RE: SSD 6339 St Catherine's School Campus Master Plan and Stage 1 development

I am writing to object to the Masterplan DA and Stage 1 proposals lodged by St Catherine's School.

TRAFFIC MANAGEMENT AND PARKING

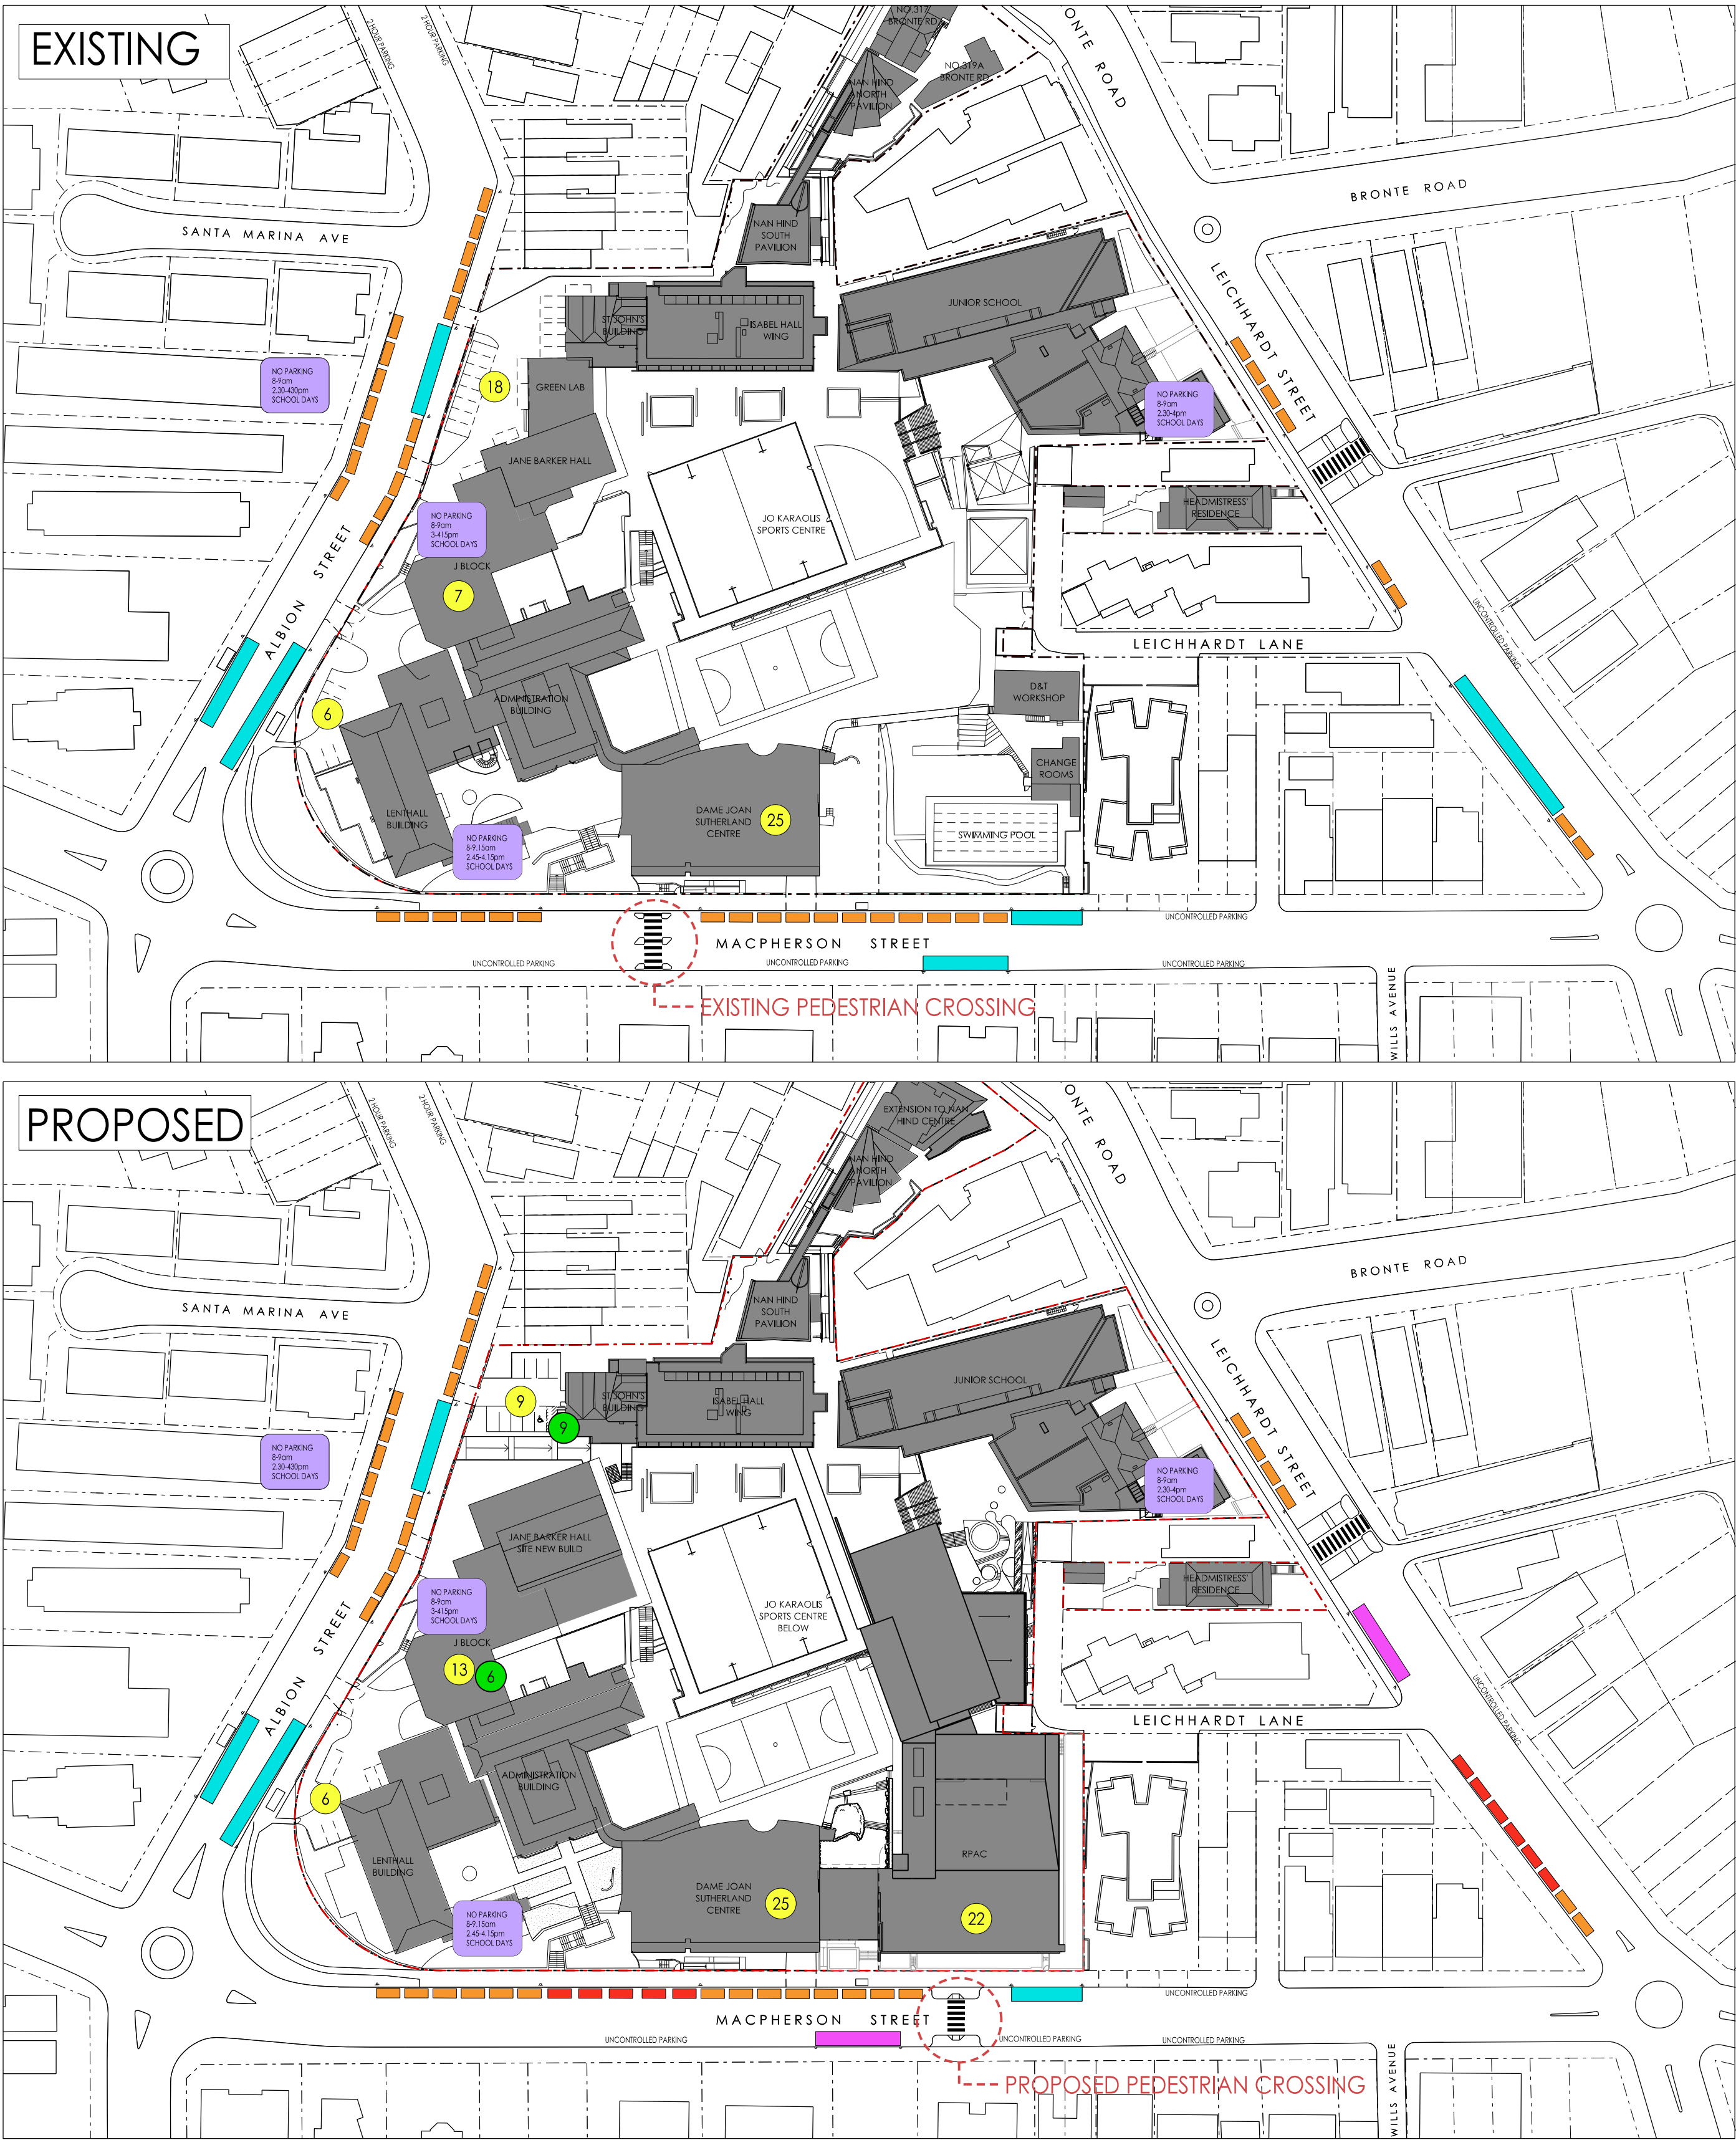
Inadequate onsite parking (only 19 new spaces)

This is the result of poor planning over the years at the school. The school has a total of only 55 spaces for its official staff numbers of 202, numbers which are set to increase. The school's own survey shows that 70% of all teachers currently drive to school, meaning at least 80 staff members are looking for parking on the local streets. This does not include tuck shop and other volunteers, cleaners and some students and visitors who drive to the school.

BUILDING OVER 9.5m ABOVE APPROX. NATURAL GROUND LEVEL

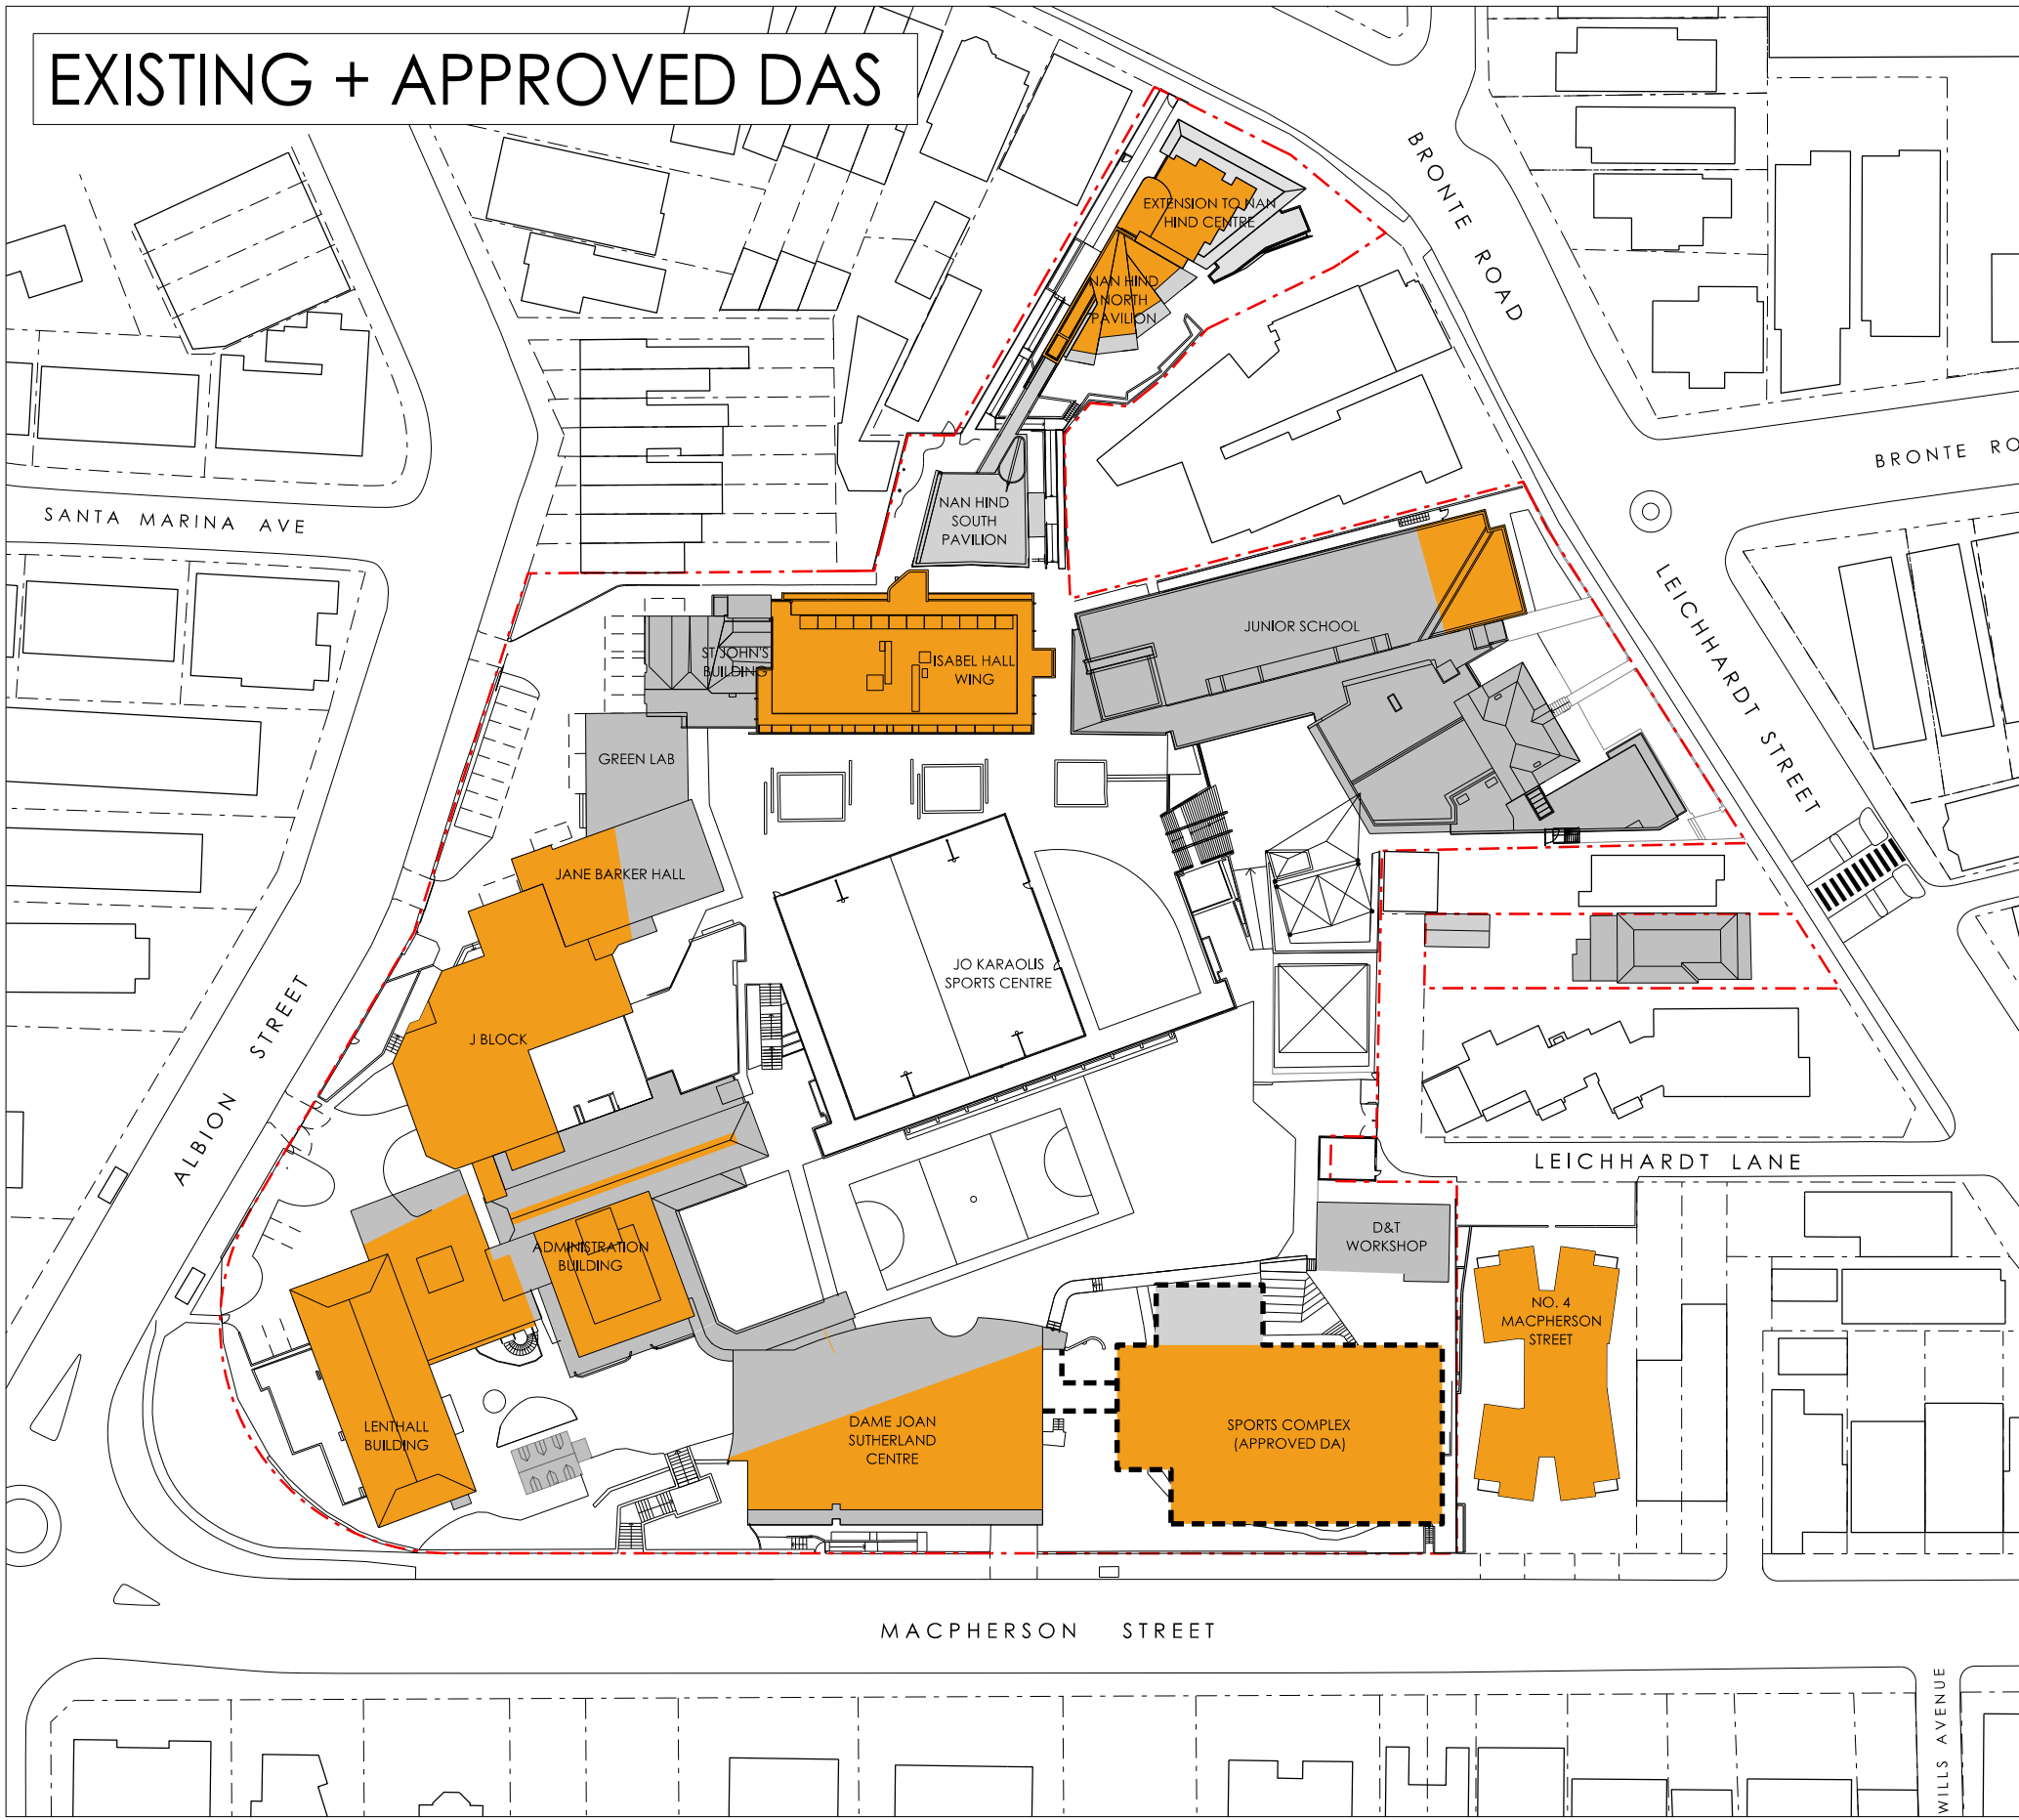
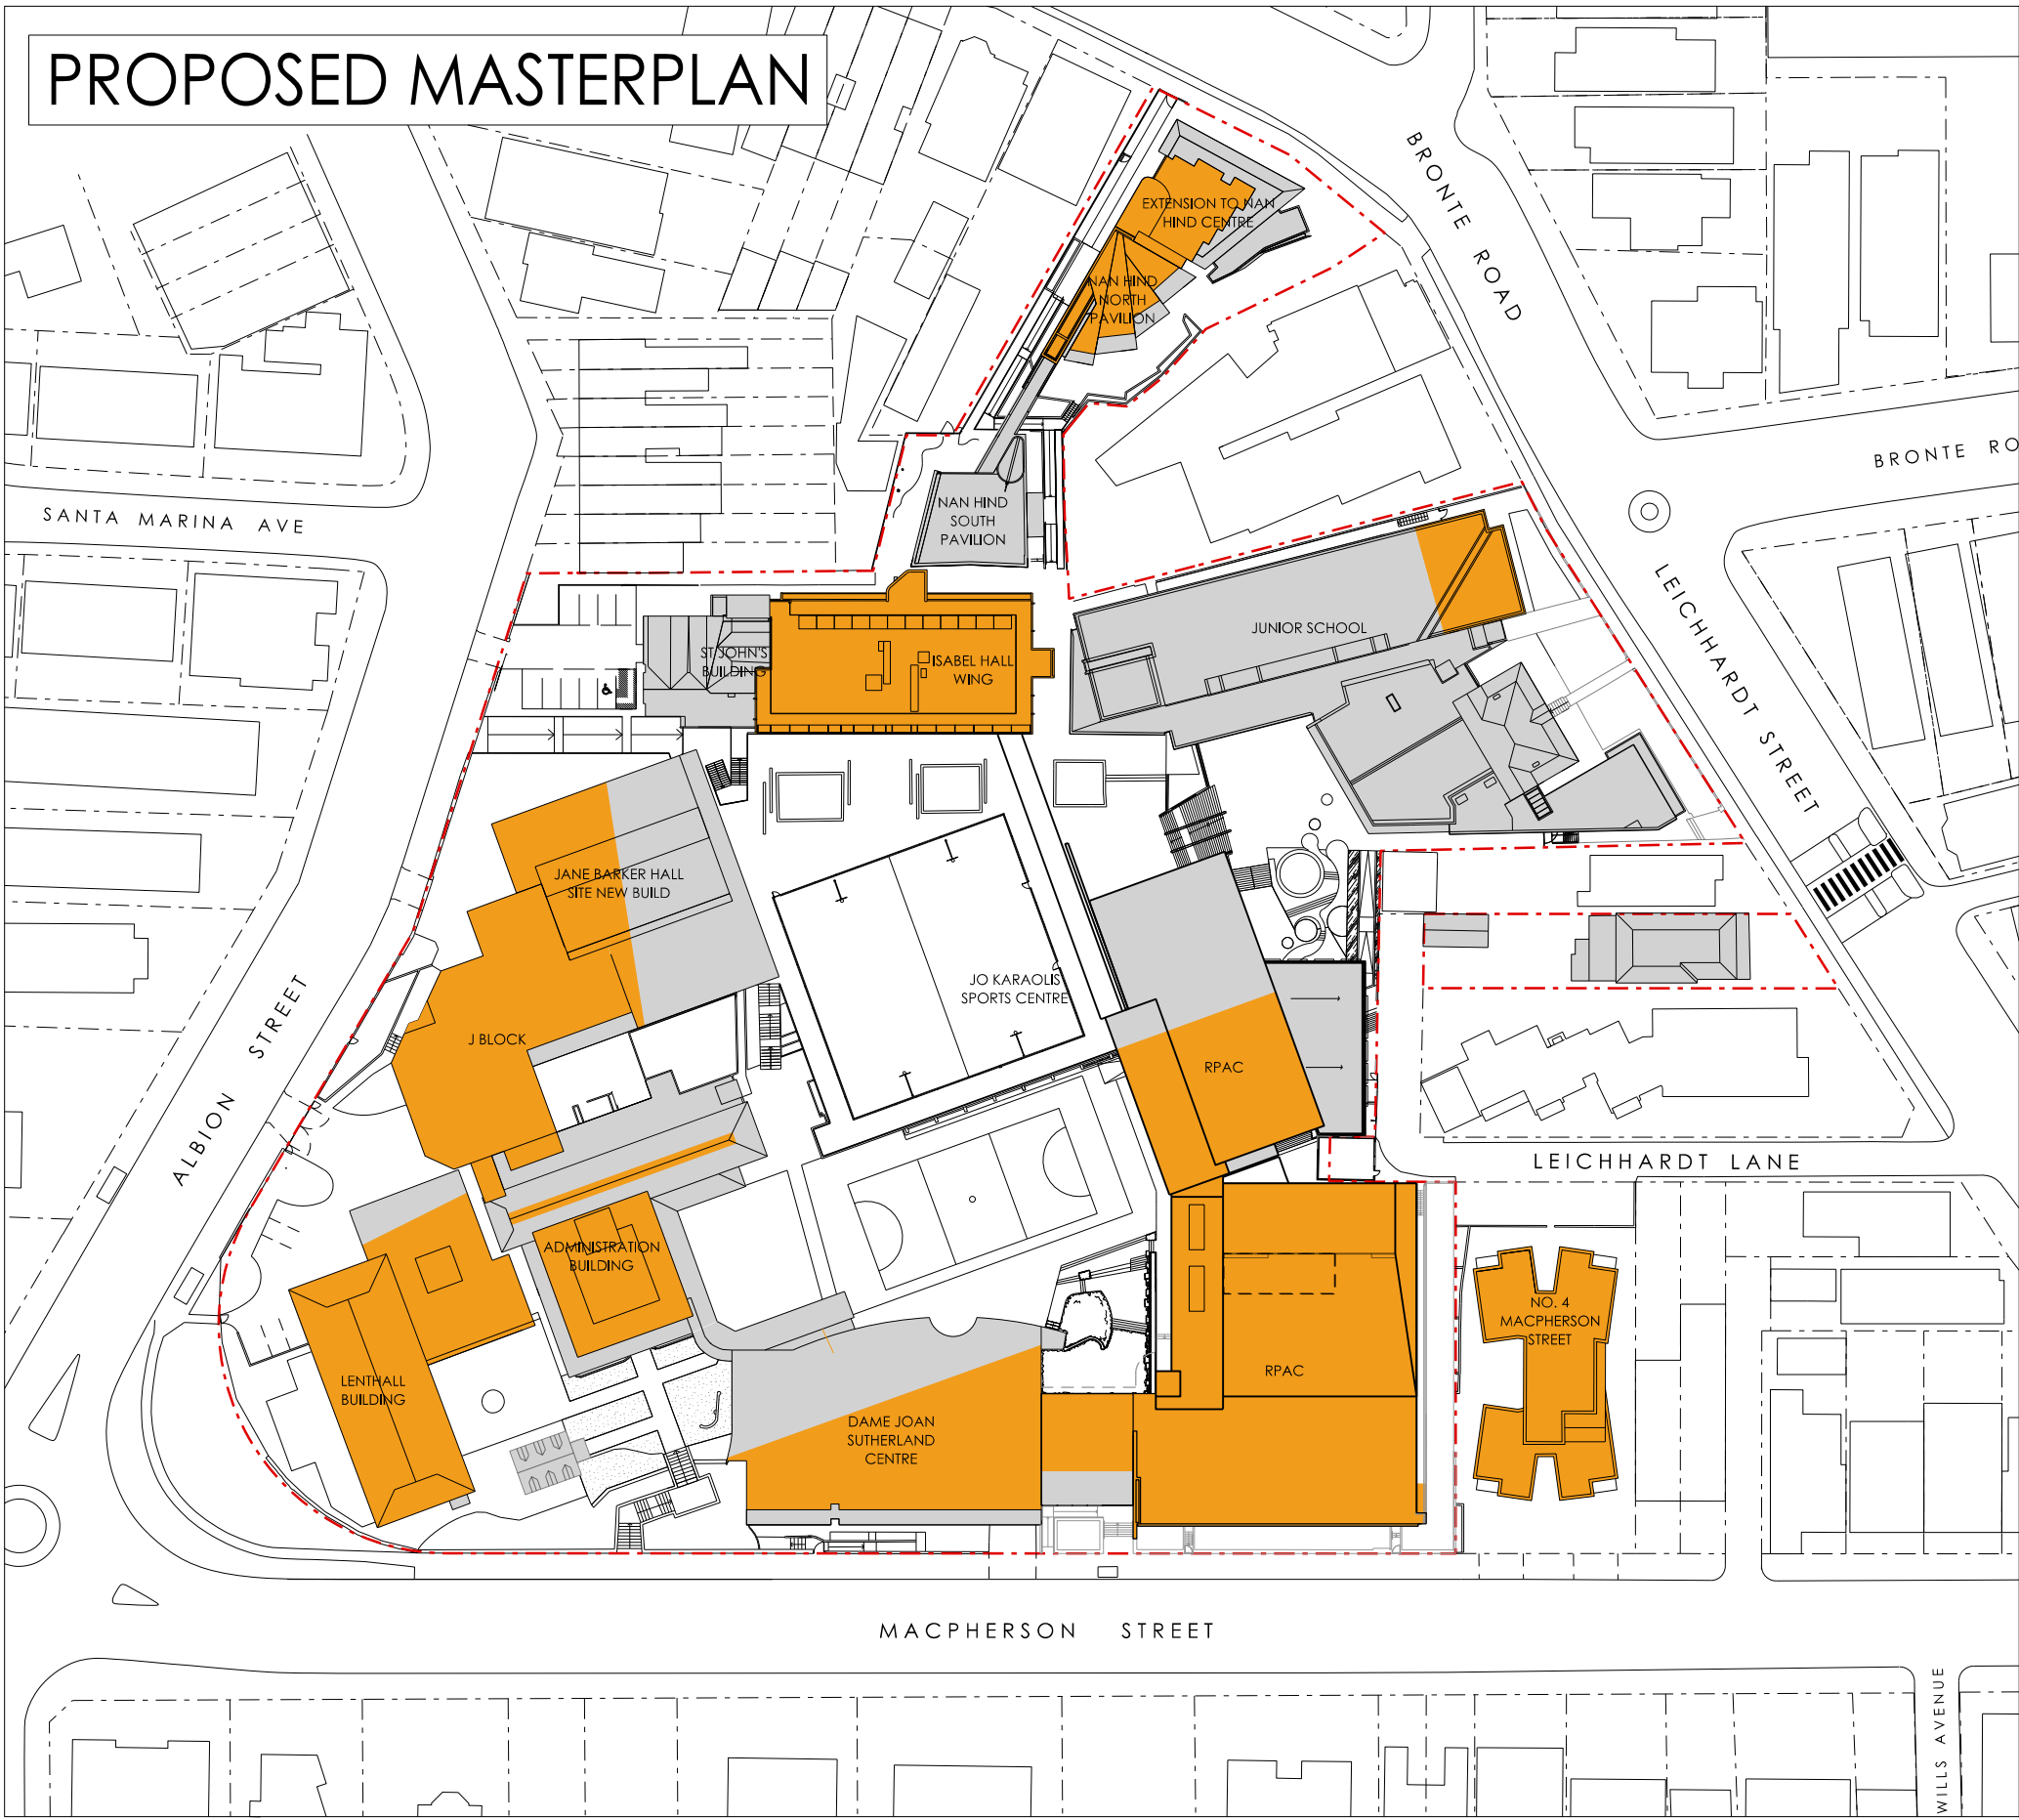
The school's property is currently zoned R2 – Low Density with a FSR limit of 0.6:1 with a building height restriction of 9.5 metres with many existing school buildings already over this height. Previous development outside planning controls have resulted in the school's existing FSR of 0.9:1, which is 50% over the FSR allowable for the site. The current proposal seeks to increase the FSR to 1:1. All of the buildings in Stage 1 will exceed allowable heights, rising to over 19 metres, or almost 10 metres over the limit.
